Application No: 320120093 P

Amendment to previously approved application for change of use of barn and garage application number- 3/2011/0004  
Amendment to include change of pitch to roof and location in the interest of highway safety.

**From:** Julia Pye Planning [jpyeplanning@gmail.com]  
**Sent:** 23 July 2012 13:11  
**To:** Louise Blatchford  
**Subject:** Re: Out Lane Head - amendments to approved application  
**Follow Up Flag:** Follow up  
**Flag Status:** Red  
**Attachments:** amended drawing to scale for louise.pdf; design and access garage.doc

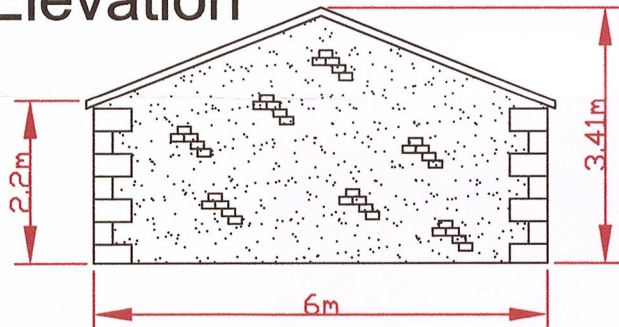
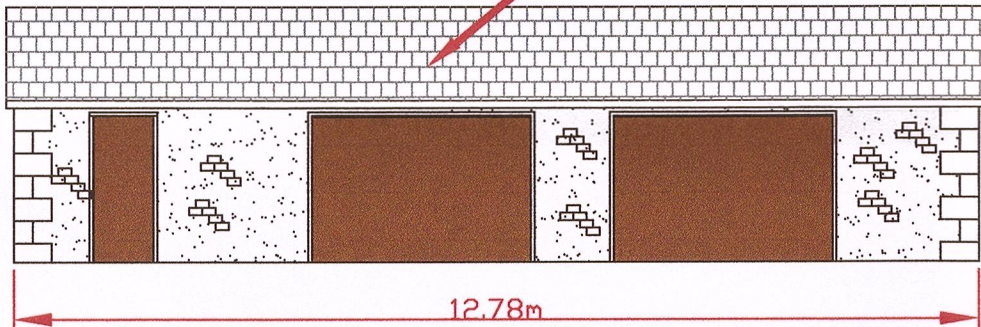
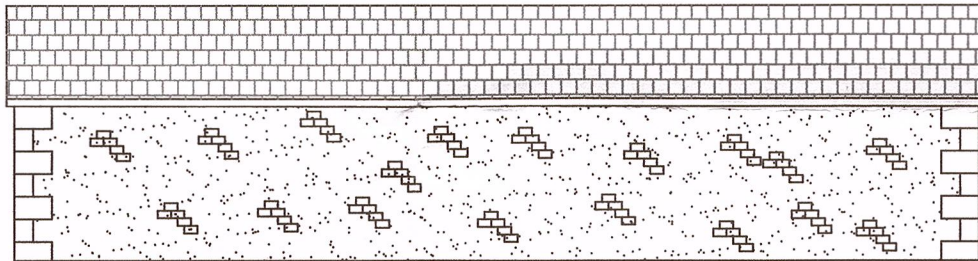
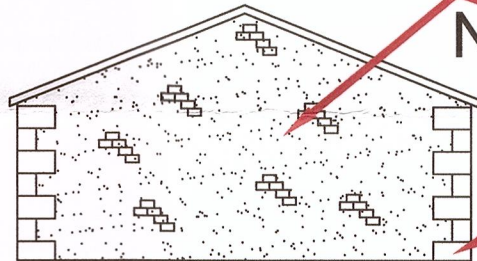
I've just been looking at the dimensions on the garage drawing and they don't measure off properly at 1:100 A3 size, please can you have a look at the drawing?

I have also had a look at the drawing and printed it off my end the one attached should scale correctly.

Proposed Ground Plan

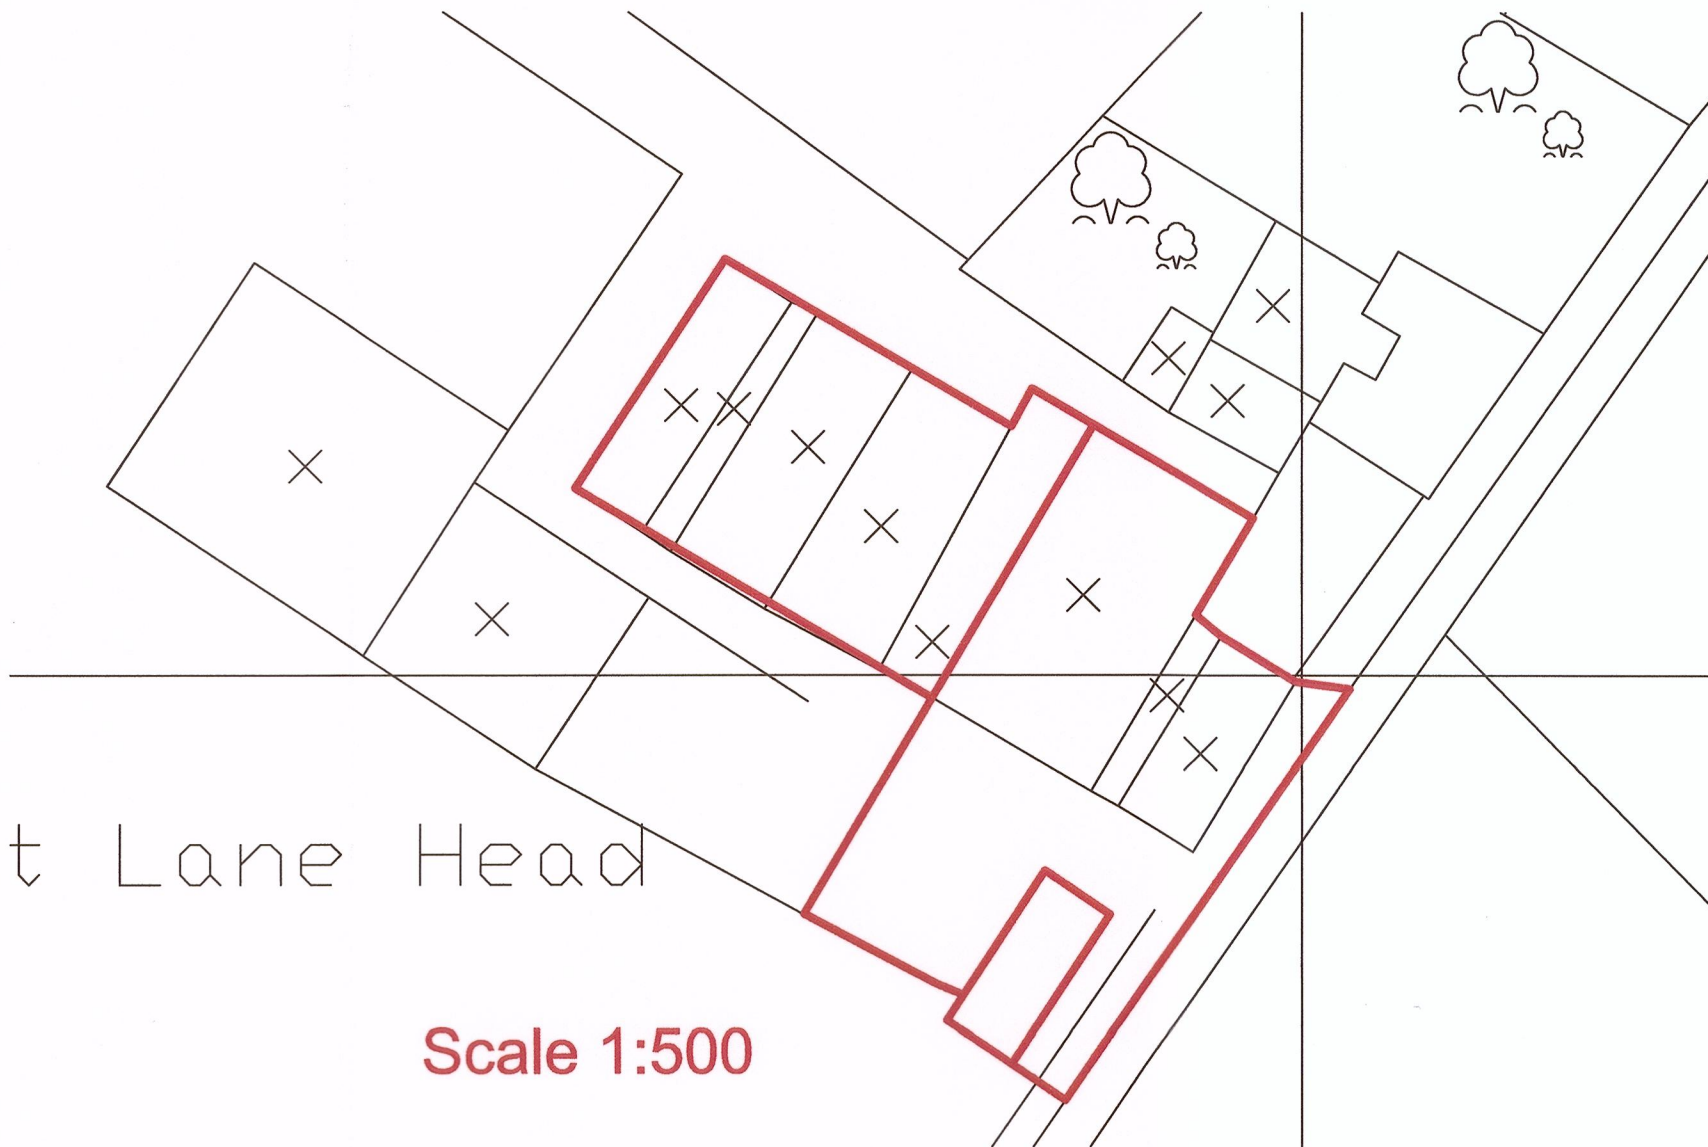
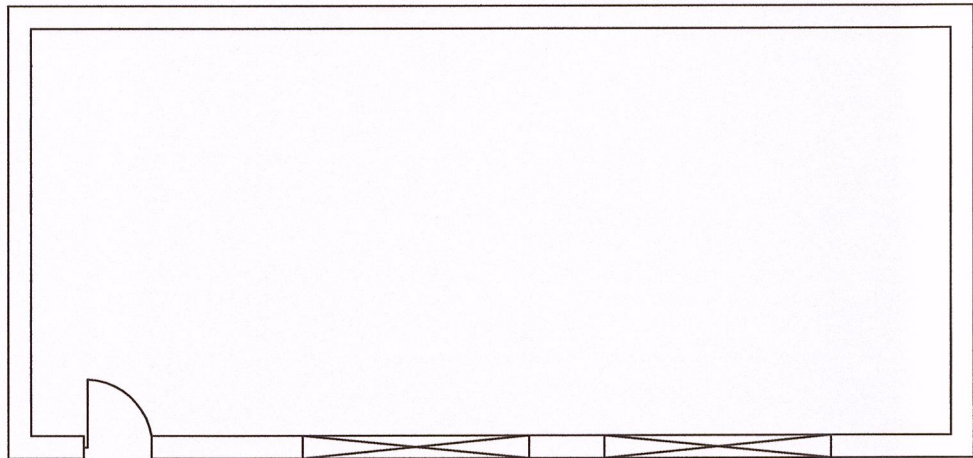
Thanks for the amended drawing, don't worry about posting any, we now have a printer that can print out to scale! I'm just thinking - I think the proposed site plan will need to show the proposed garden area and parking area for the converted dwelling.

- Out Lane Head - extensions to two agricultural buildings - discrepancies between dimensions on floor plans and elevations (North and South elevations), question 18 needs altering and dimensions need to be made bigger on the elevations.
- Out Lane Head - amendment to 3/2011/0004 - only have plans showing existing building and proposed garage (none of the elevations or floor plans labelled). Need location plans, site plans and design and access statement
- 3/2012/0089 Lanshaw Barn - need a proposed site plan, also the dimensions of the existing looks bigger than the proposed development.
